City of Portland, Maine - Building or Use Permit Application

REASON FOR PERMIT: New 28'x36' duplex dwelling unit

**CITY OF PORTLAND, ME
BOCA 1999 Plan Review Record
One and Two Family Dwelling**

Building Description: Duplex Dwelling unit 151-B-8e9

PROPOSED SITE PLAN
 OF THE
L' HEUREUX PARCEL
 117 WOODLAWN AVENUE PORTLAND, MAINE
 CUMBERLAND COUNTY
 PREPARED FOR
MICHAEL L' HEUREUX
 506 MAIN STREET LEWISTON, MAINE

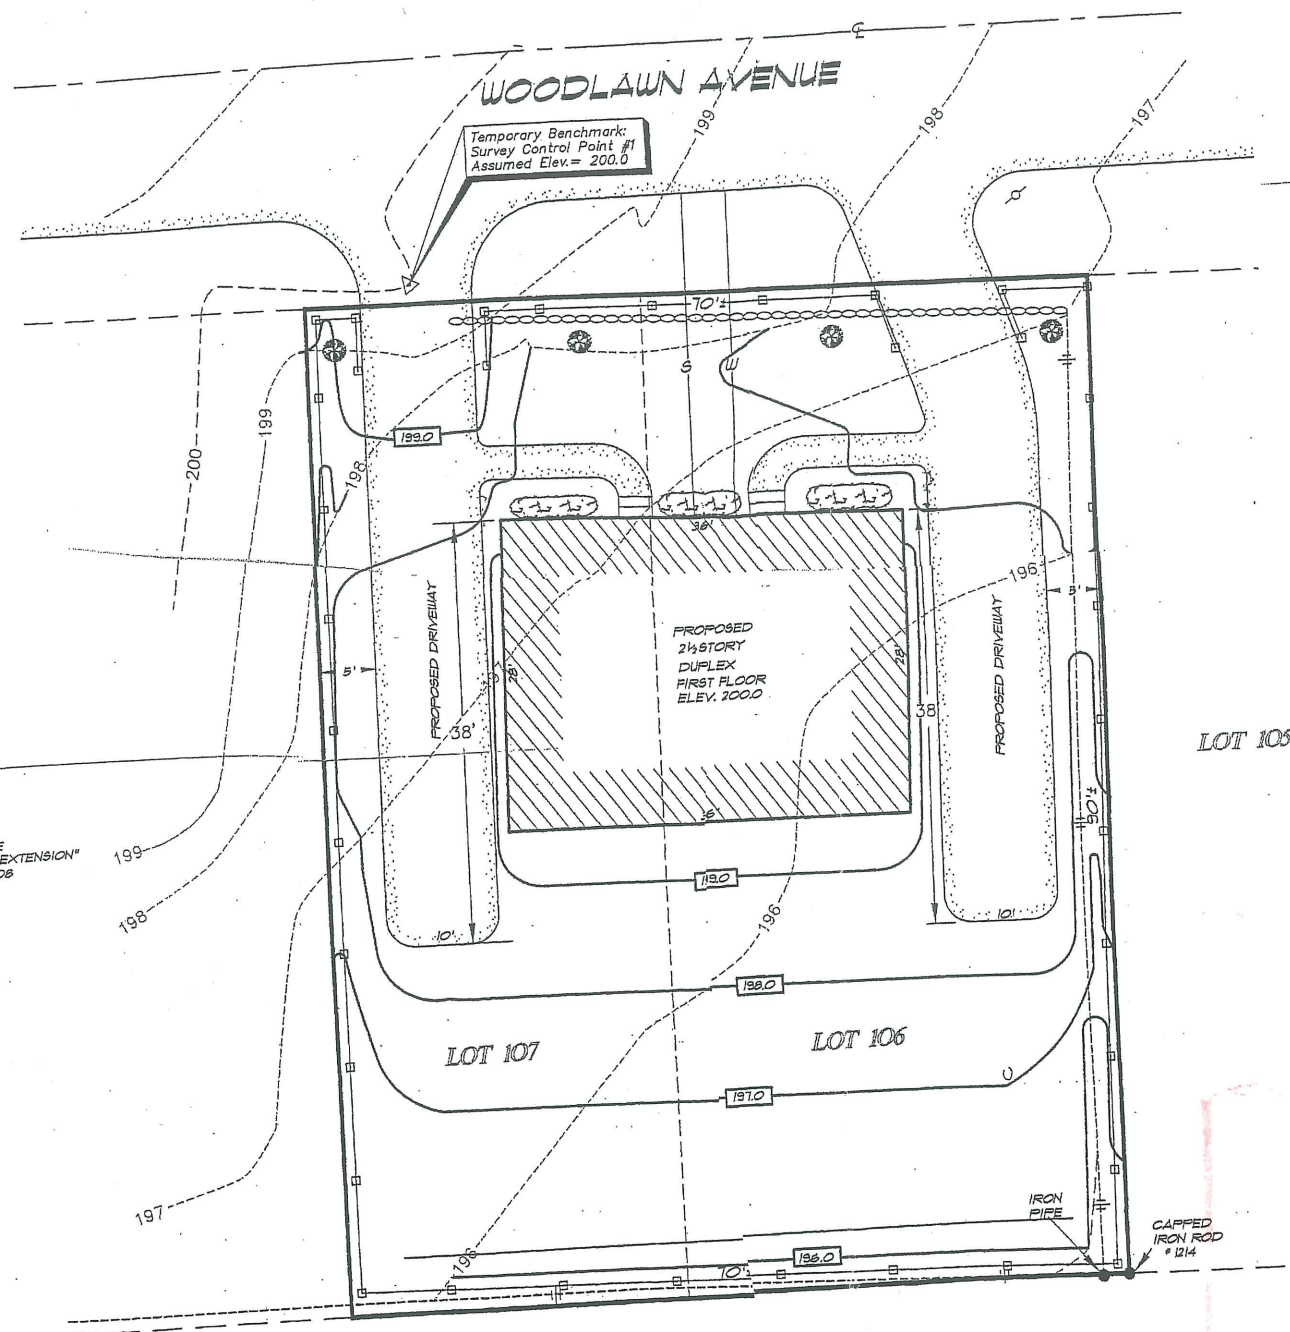
Parking area Needed to be extended beyond the front yard
No Parking in front yard

15. X Applicant shall install rain gutters to structure to direct water to ~~the~~ street.

16. X Applicant shall grade the lot to shed water to the street
